Subject: Callout
Page Index: 2
Date: 4/22/2022 9:13:16 AM
Author: dsdrice
Color: 
Layer:
Space:
Page Label: [1] SHT 2 EC INITIAL

Subject: SW - Comment
Page Index: 6
Date: 4/7/2022 12:17:49 PM
Author: EPC Stormwater - Glenn Reese
Color: ■
Layer:
Space:
Page Label: [1] SHT 6 FINAL

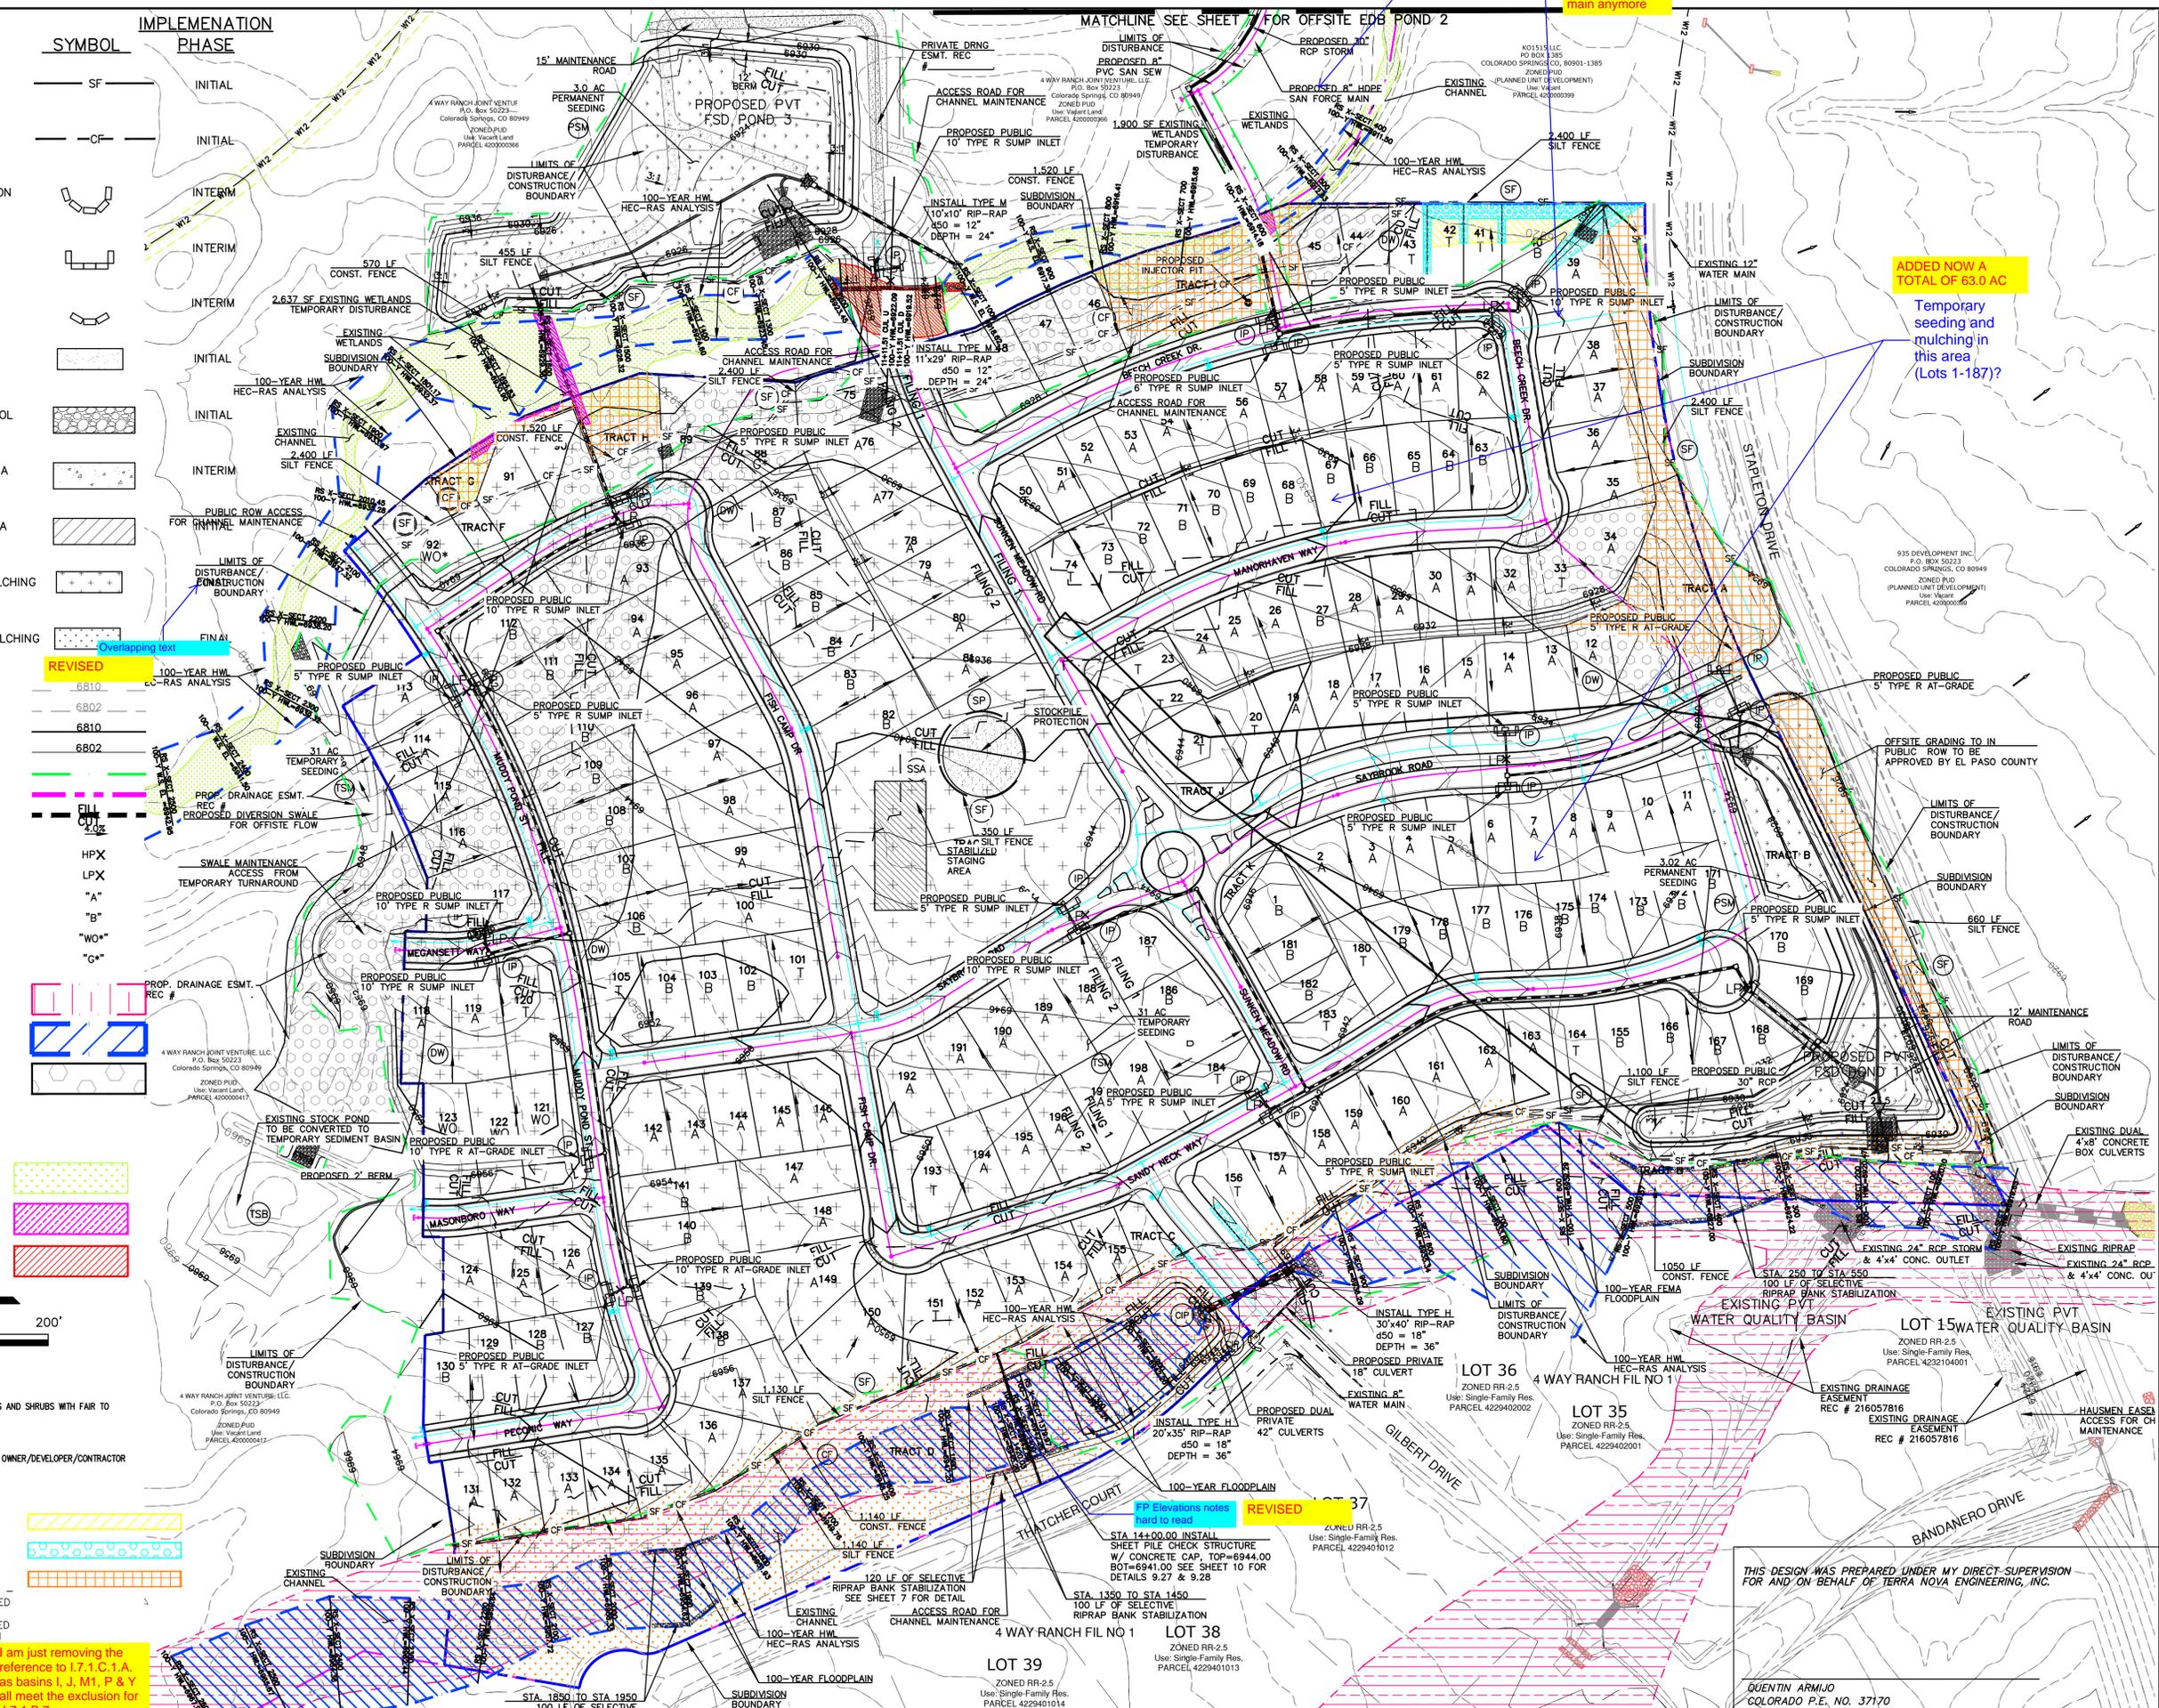
Unresolved comment from Review #1 and #2: Item H and M. If "limits of disturbance" and "construction boundary" are the same, change to "construction boundary/limits of disturbance" or otherwise show as separate linetypes for each on the legend and figure.

show all contours

Curb and gutter shouldn't be out this far

See PDR and comment letter regarding channel design.

Show maintenance road to outlet structure
